Subject: RE: *External:RE: *EXTERNAL: Drove Lane Sales Cabin refs Y/141/21/PL and Y/142/21/A

Hi Sean,

I spoke with Vicky Newman at the Parish Council and she has said that:

Client: Barratt Southern Counties
Site: Ryebank Gate
Job No: Q81095 v4
Date: 24/05/2021
Designer: SM

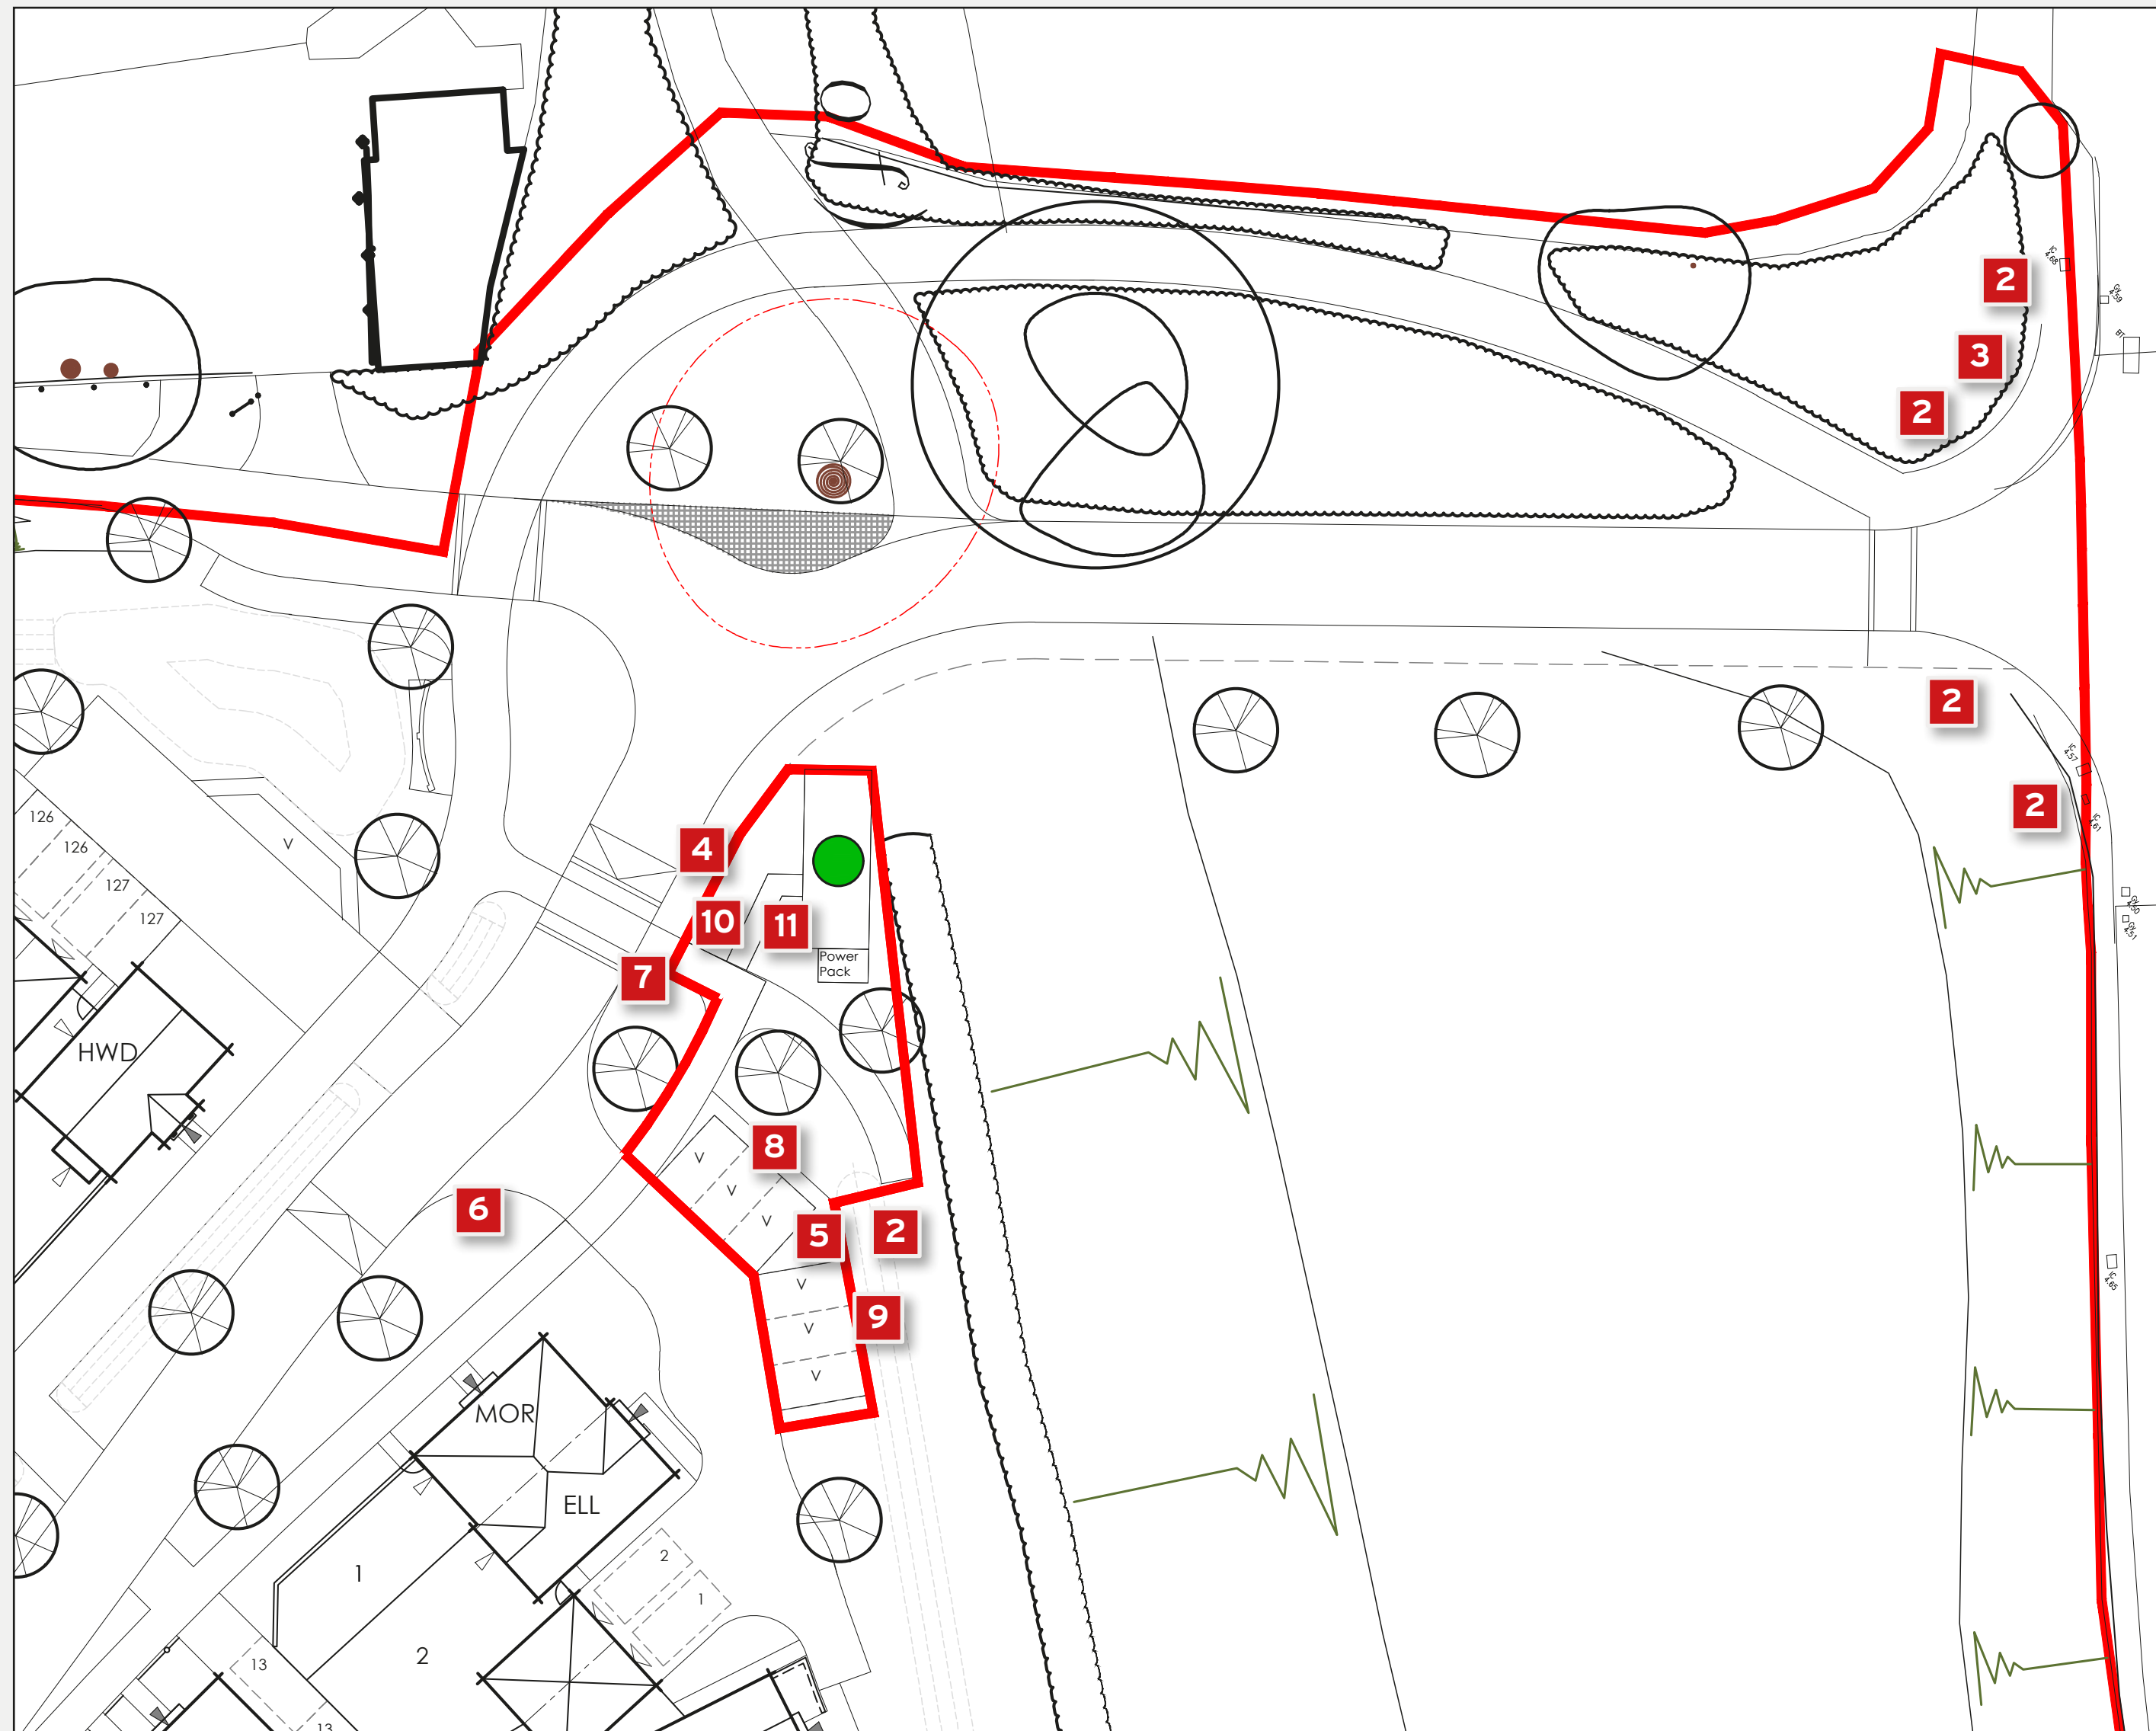
"The PC concern was the level of signage fronting Main Road hence the objection. By adding a further two 12foot totems isn't going to remove or indeed lessen the clutter on the frontage. I would strongly suggest the applicant simply has one totem and no more fronting the main road as per other house builders in Yapton."

I have pointed out that the Parish previously stated no more than 2 signs of any size on the frontage.

As you mention, we have taken the Parish Council's comments (dated 1st November 2021) on board. We have amended the advertising plan accordingly with the signage on Main Road "*reduced to no more than 2 advertisement signs of any size*".

Due to the development being a 'dual-brand' site and incorporating both our David Wilson and Barratt brands, we are unable to reduce the number of signs further as we need separate signs that relate to each of the brands.
